Rezoning Transportation Analysis
Petition Number: Insert Zoning Petition #2021-206
General Location Identifier: 04729144

Revision Log:	Date	Description
	01-27-22	First Review (TM)
	02-24-22	Second Review (TM)
	03-30-22	Third Review (PDM)

The petition is located adjacent to Olmsted Drive, a City-maintained local street and North Tryon Street, a State-maintained major thoroughfare. The petition is located in the North East Wedge outside Route 4.

REZONING PETITION 2021-206
 RZ-2 : TECHNICAL DATA SHEET

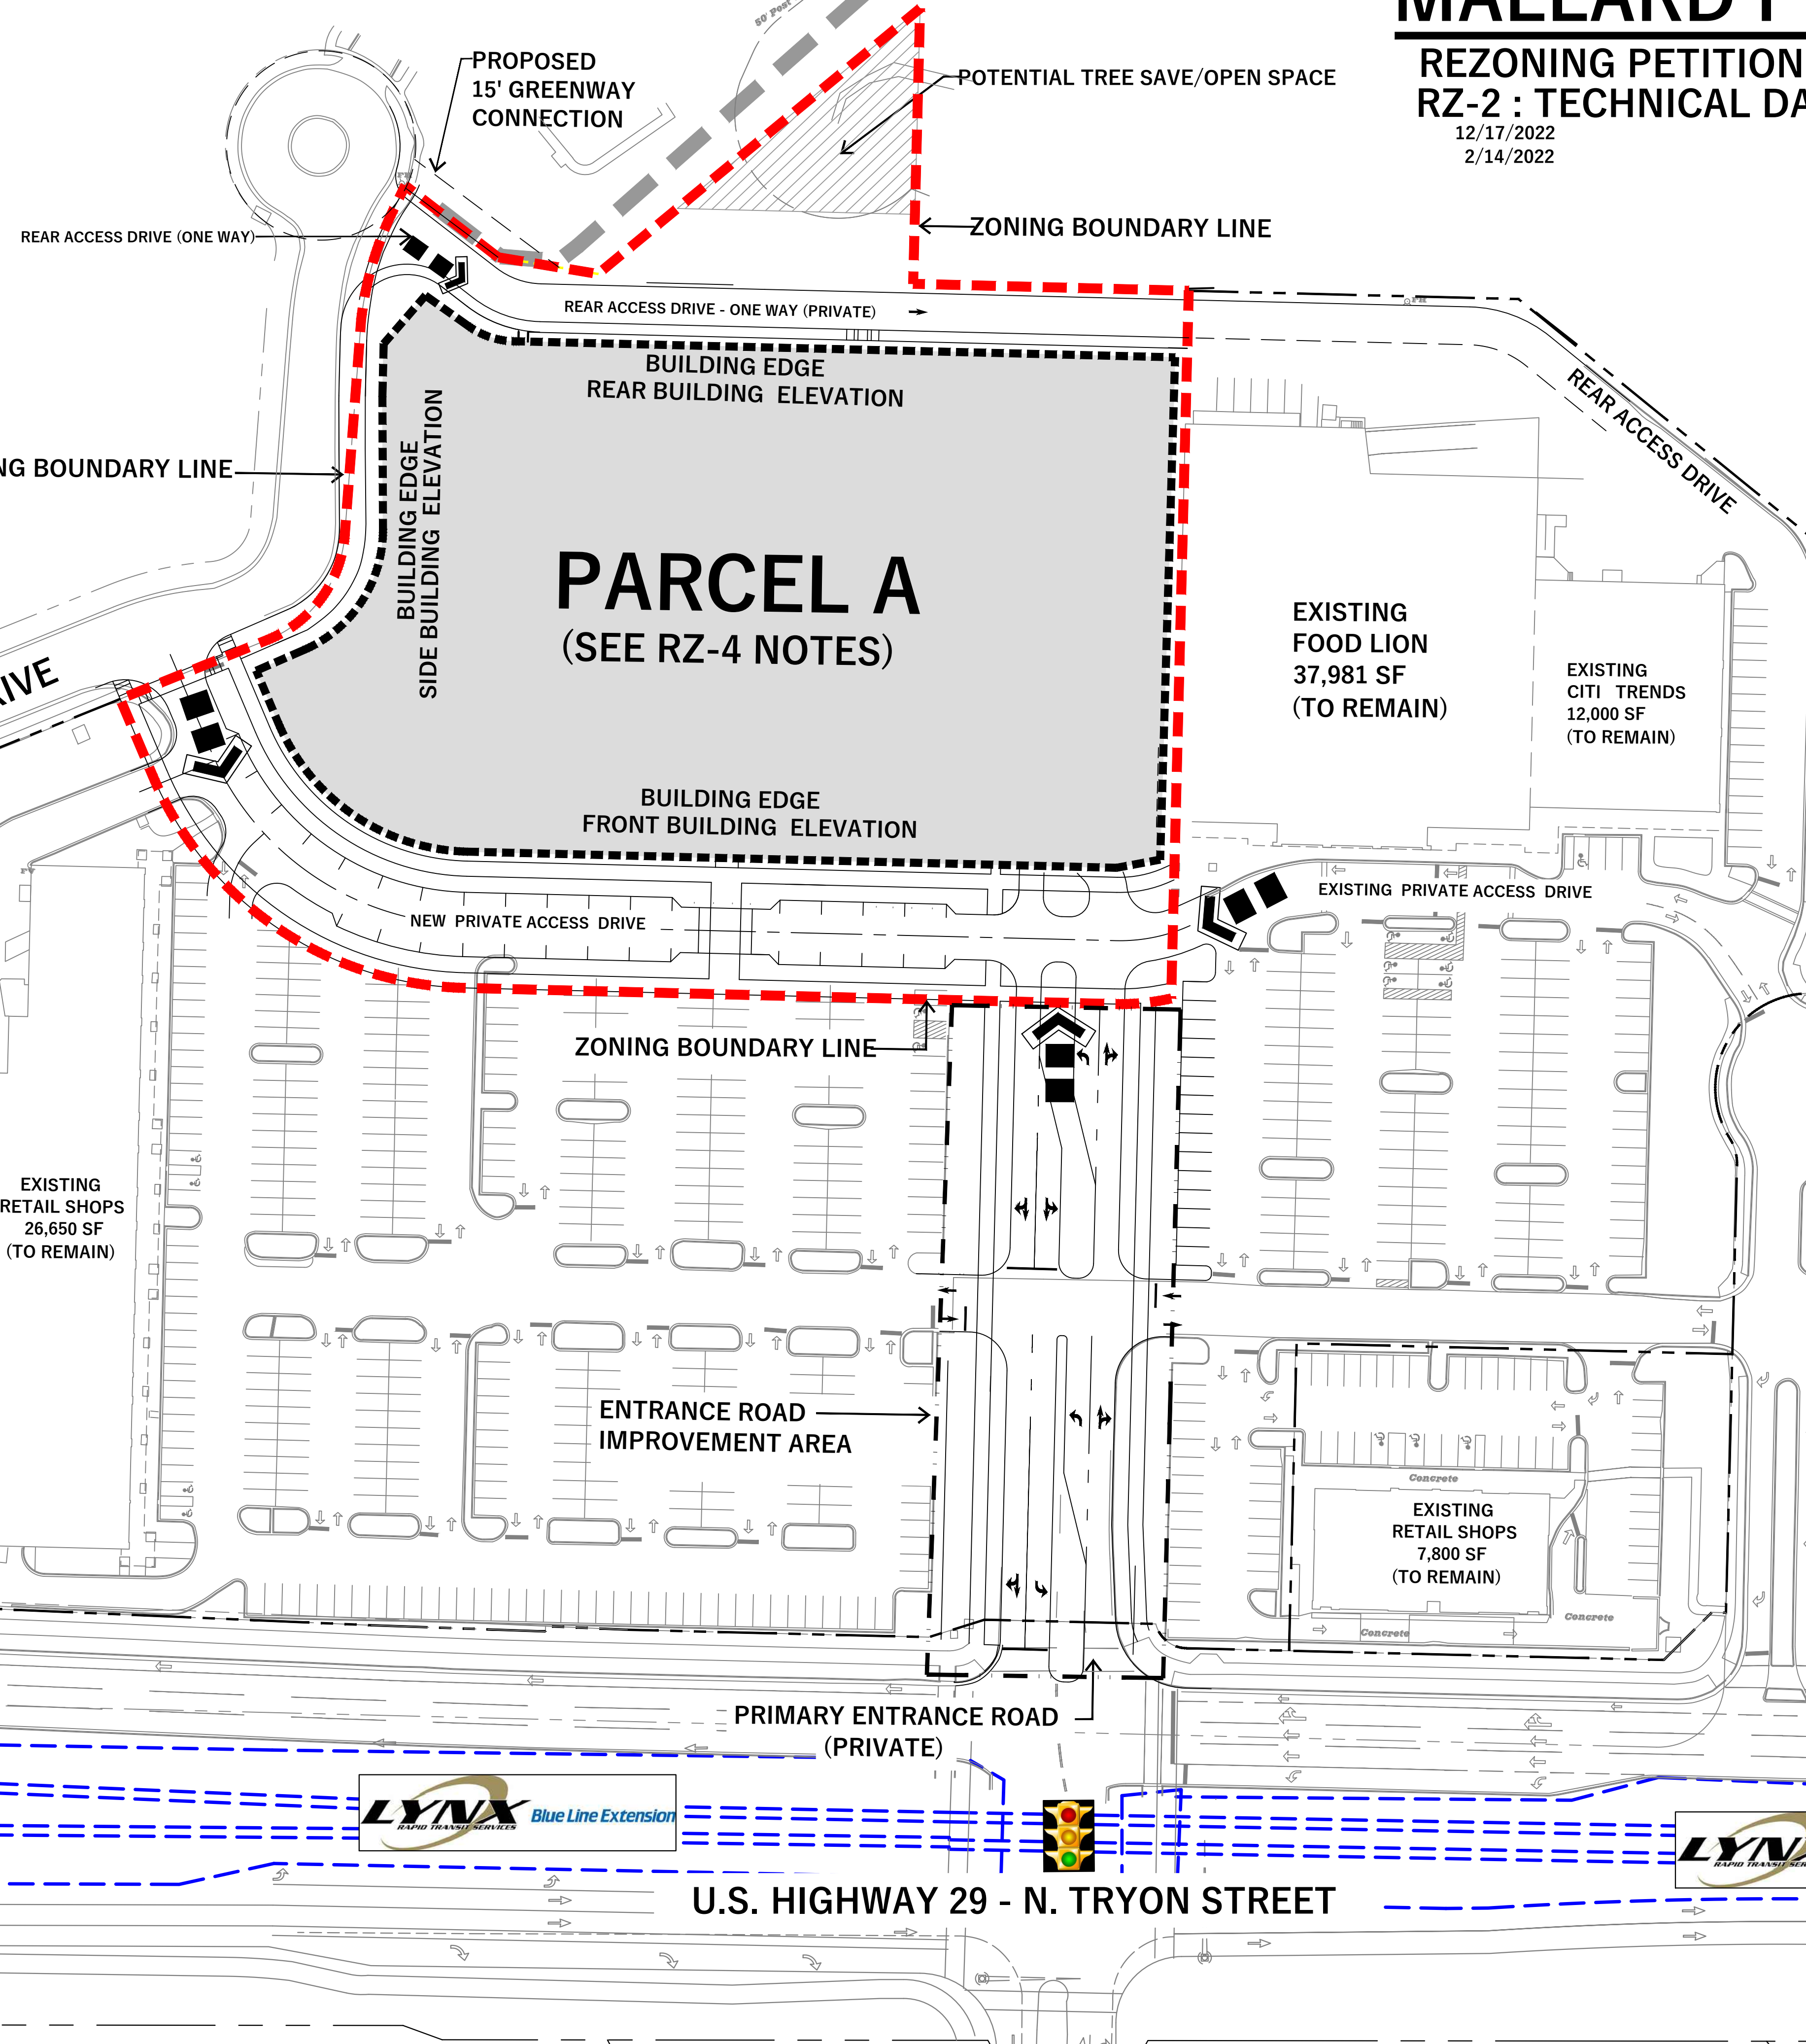
d. The existing sidewalk along Olmsted Drive shall be preserved, however a sidewalk easement shall be granted to CDOT in the areas that the sidewalk is outside of the right-of-way. CDOT requests sidewalk utility easement set a 2-feet behind back of sidewalk where feasible.

- 12. **New Comment from 03.30.2022:** Revise site plan to clarify location of the sidewalk utility easement along Olmstead Drive. Sidewalk utility easement should be set a 2-feet behind the back of sidewalk in locations where the sidewalk is outside of the ROW.
